**ADC Planning Consultation
Response from the Historic Buildings Adviser**

Application Number	AL/66/15/DOC
Address	Meadow Cottage, Aldingbourne
Description	Application for approval of matters reserved by condition imposed under AL/11/15/L relating to conditions 3, 4 & 5 for details of construction & materials of external joinery & new glass roof & details of internal wall insulation.
Case Officer	Simon Davis
Site Visit

## New garage room windows at scale 10:1

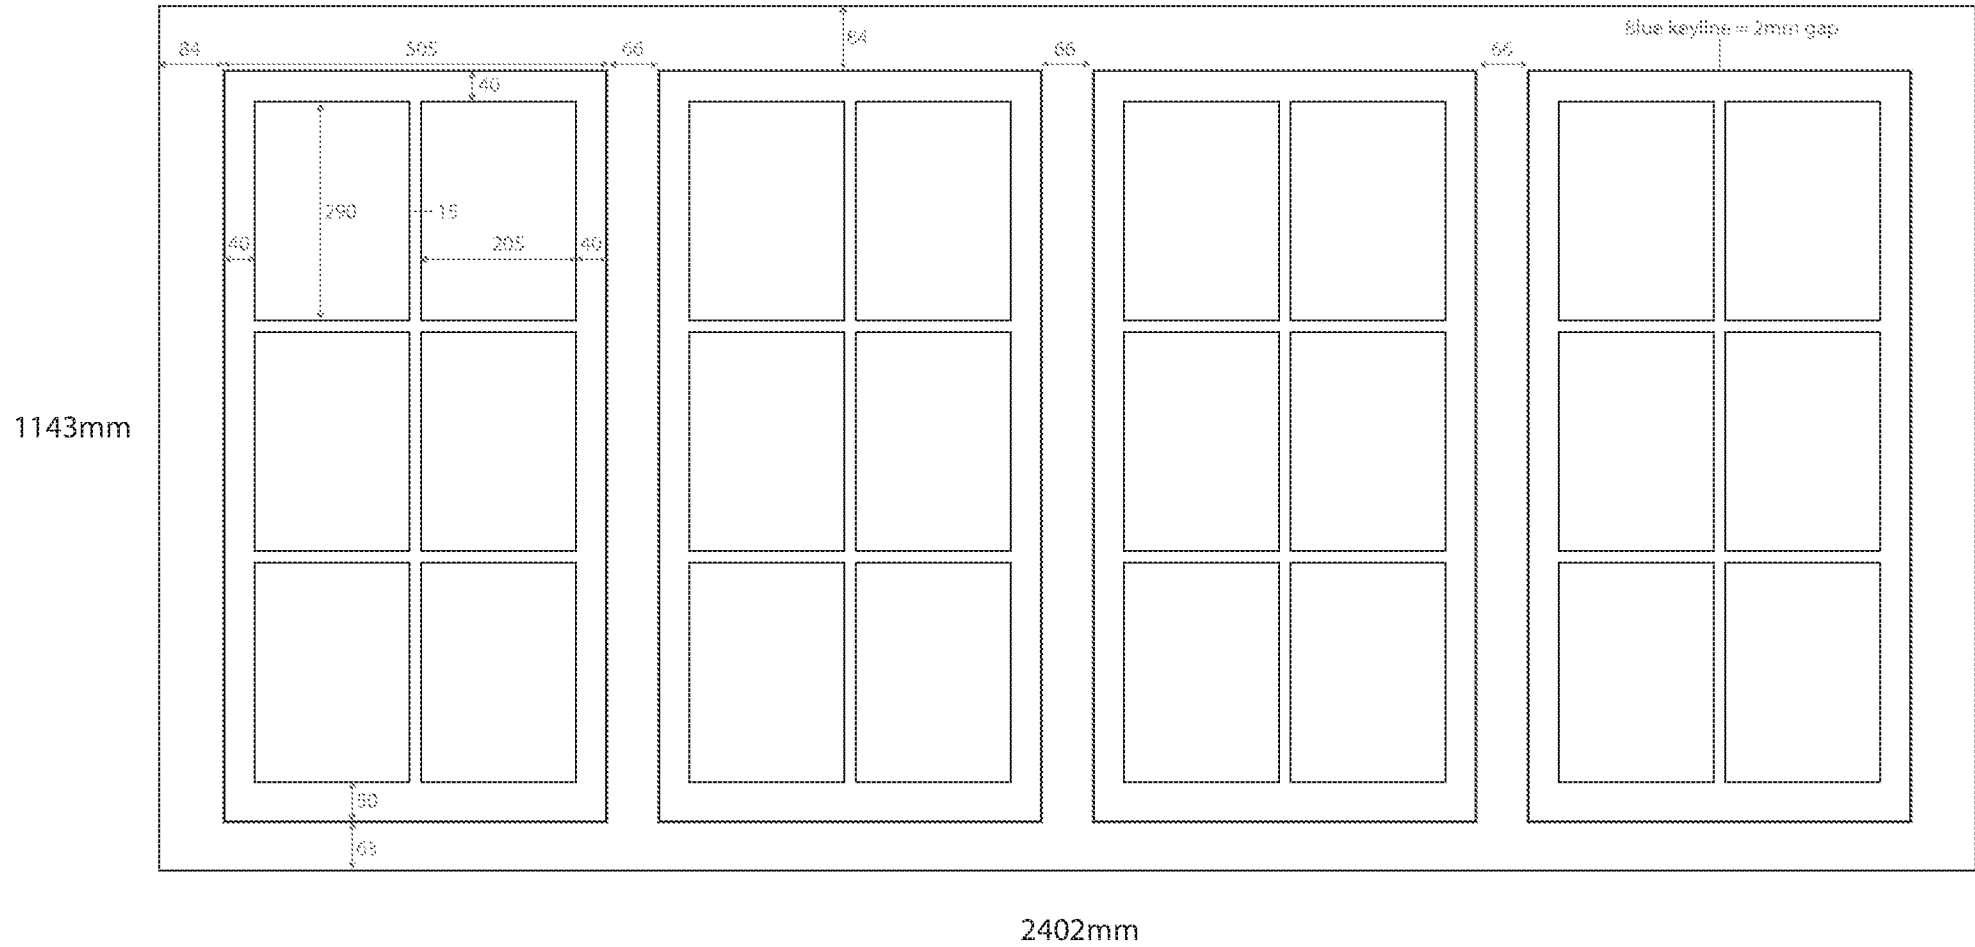
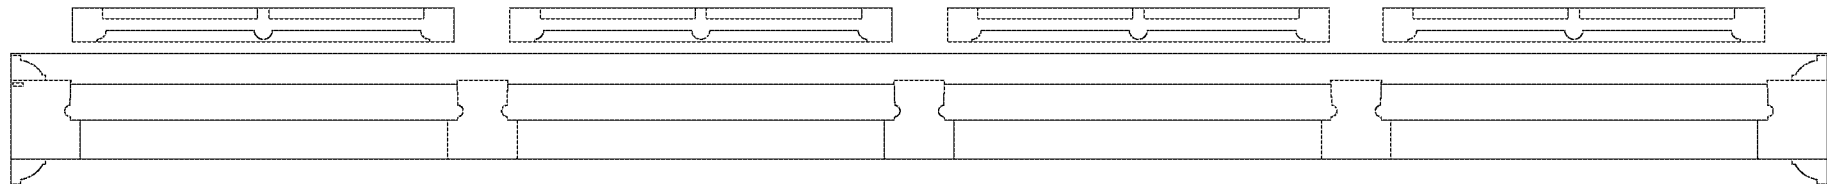
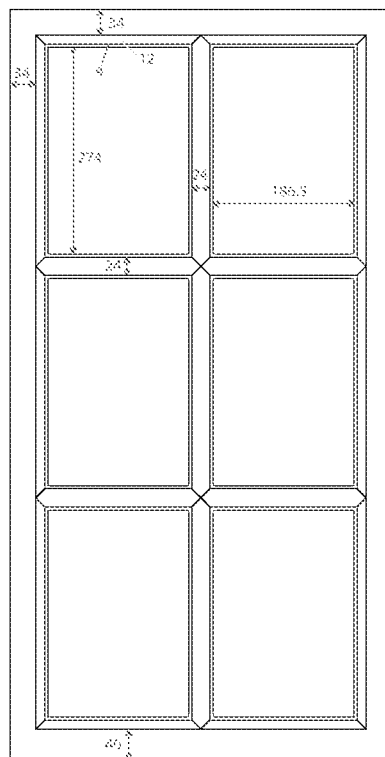
Condition 3: The joinery details are all generally acceptable however there appears to be no detail of the glazing for the 'garage' windows. As this is a later extension a slim 11mm glazing system would be acceptable. The double glazing detail, which I assume is for the rear doors, is very thick (24mm) and should be reduced to improve its appearance.
